Rezoning Transportation Analysis

Petition Number: 2020-057

General Location Identifier: Tax ID11303105A

Date	Description
05-18-20	First Review (EL)
06-29-20	Second Review (EL)
08-20-20	Third Review (KP)

Schematic Site Plan Rezoning Petition #2020-057

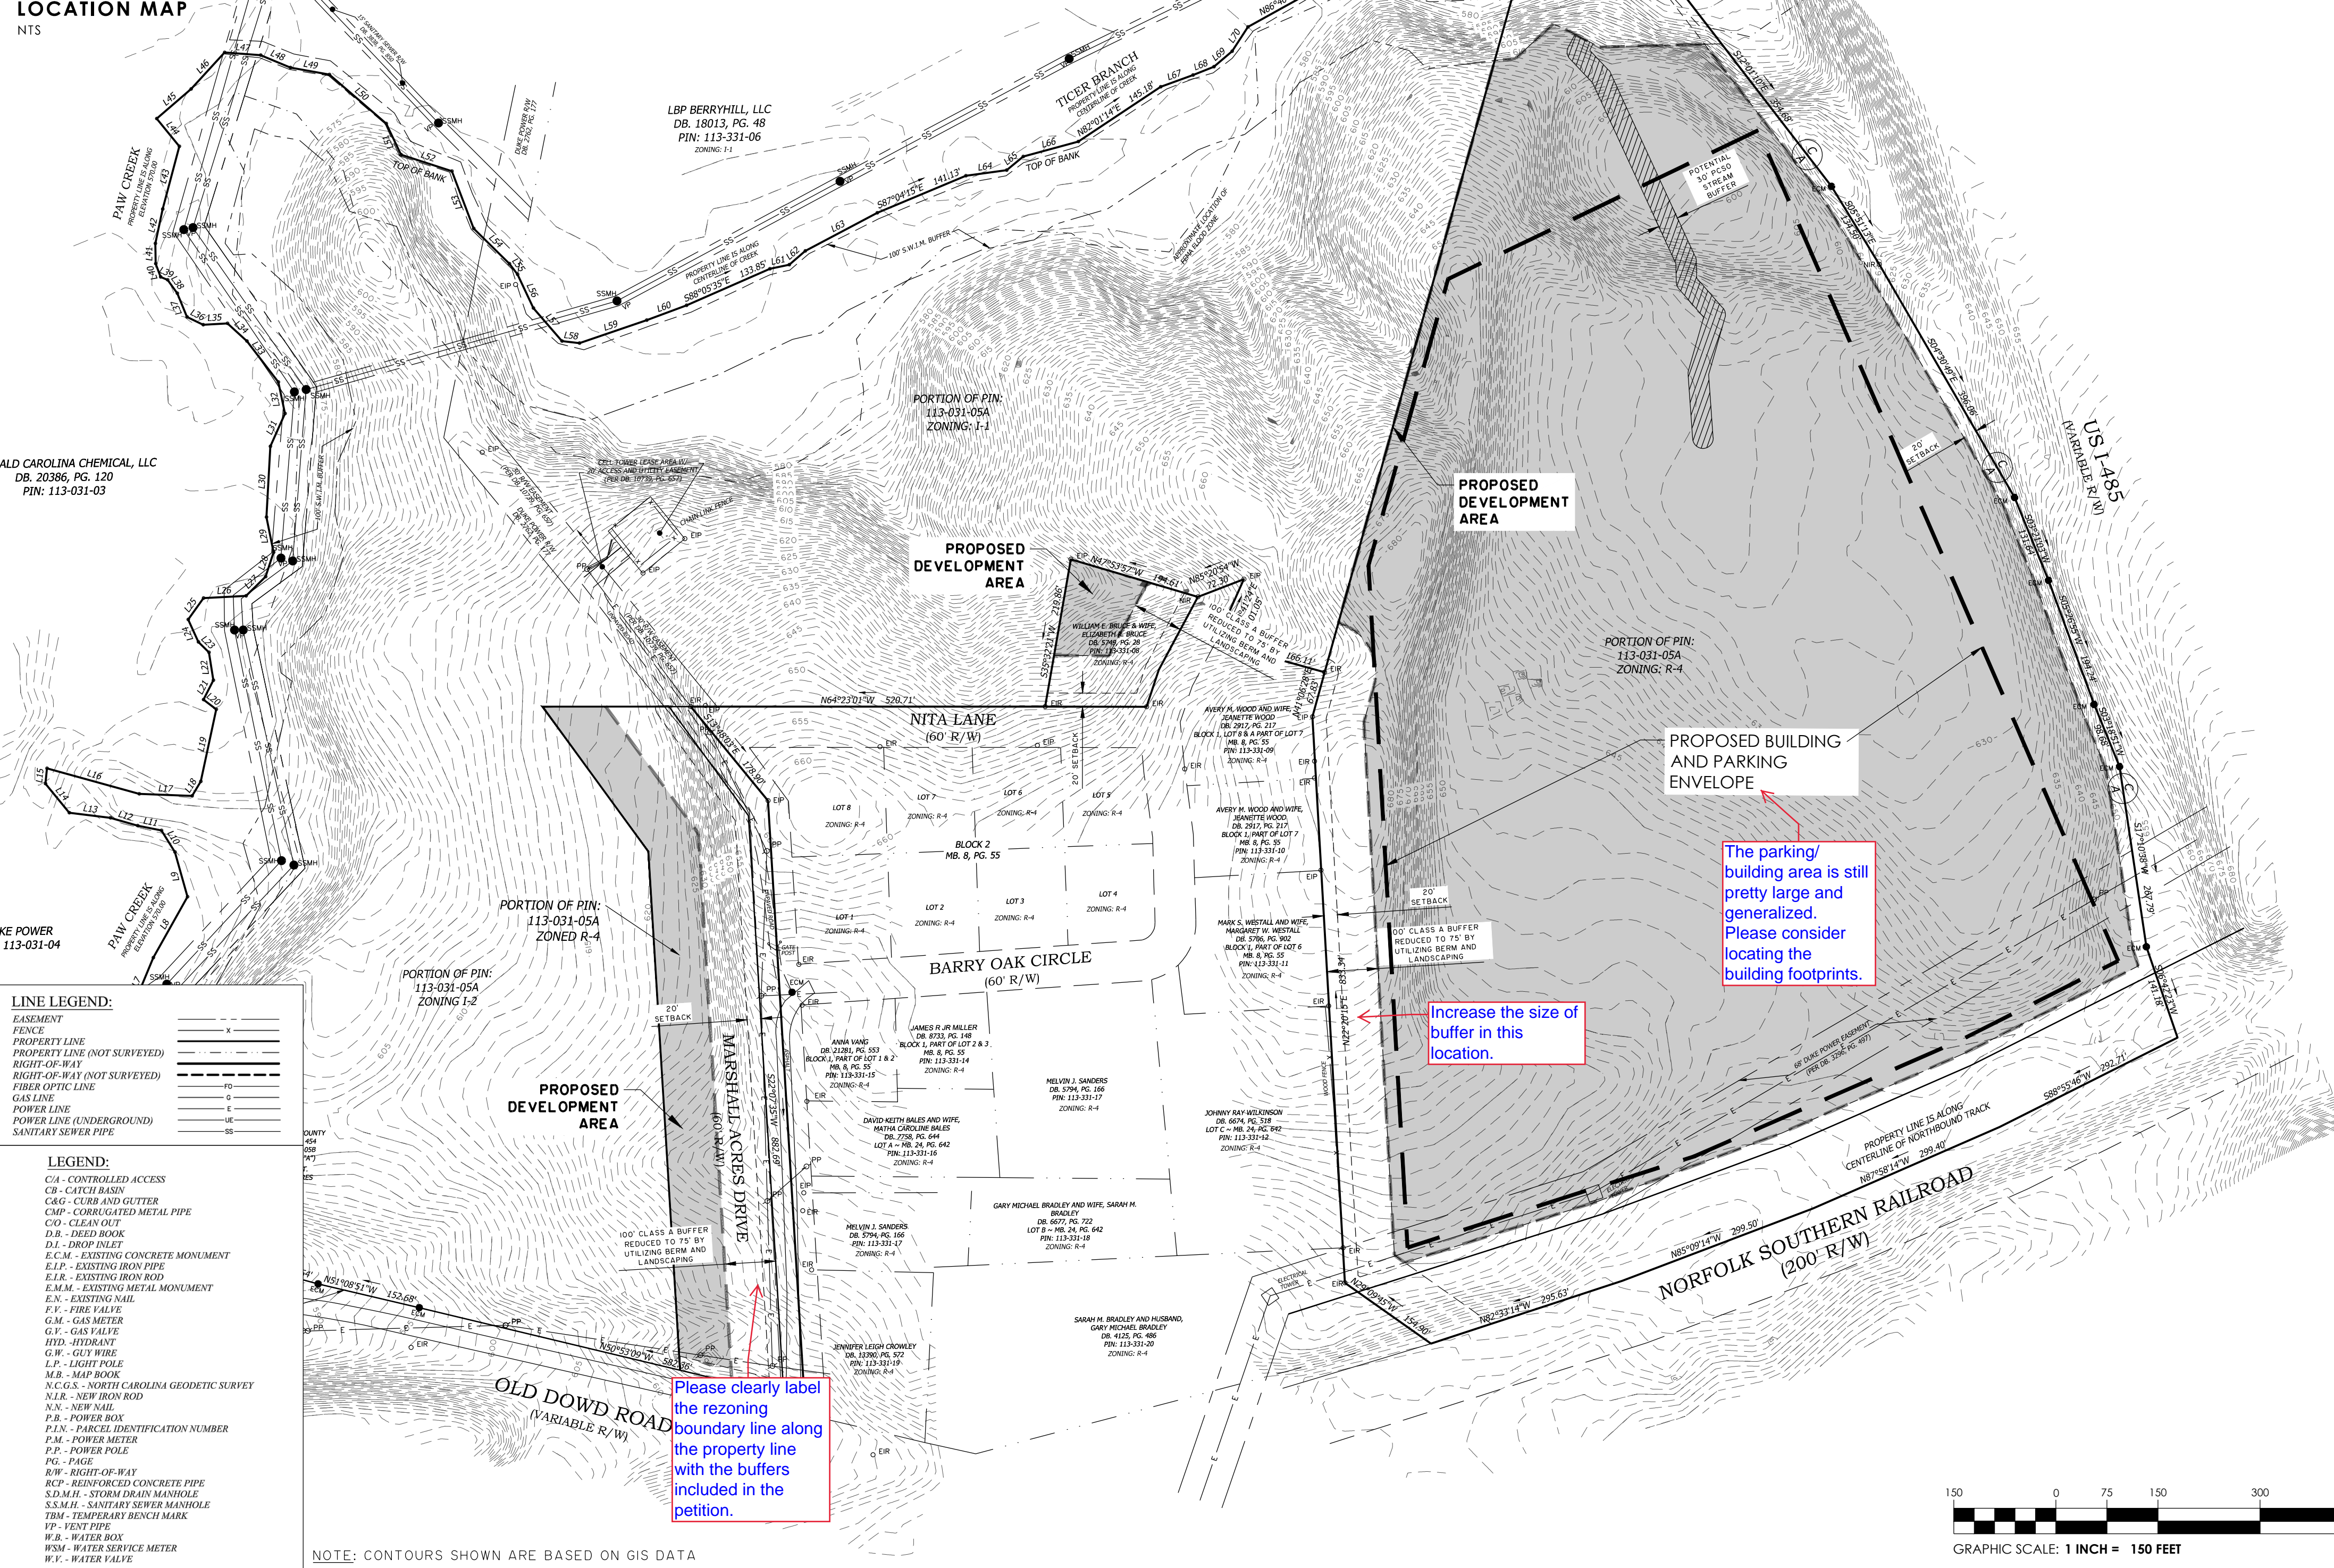
5. **Outstanding** The petitioner should revise the site plan and conditional note(s) to commit to construct an 8-foot minimum planting strip, and 6-foot sidewalk on existing Old Dowd Road per Chapter 19 of the City Code. The site plan should label and dimension both items from the edge-of-pavement/shoulder and road centerline.

6. **Outstanding** The petitioner should revise the site plan and conditional note(s) to commit to construct an overland connector along the future Paw Creek Greenway on existing Old Dowd Road to meet the City of Charlotte BIKES Policy and Greenway Master Plan.

7. **Outstanding** The petitioner should revise the site plan and conditional note(s) to confirm whether the proposed development will consist of one or two buildings, to determine applicability of the Subdivision Ordinance.
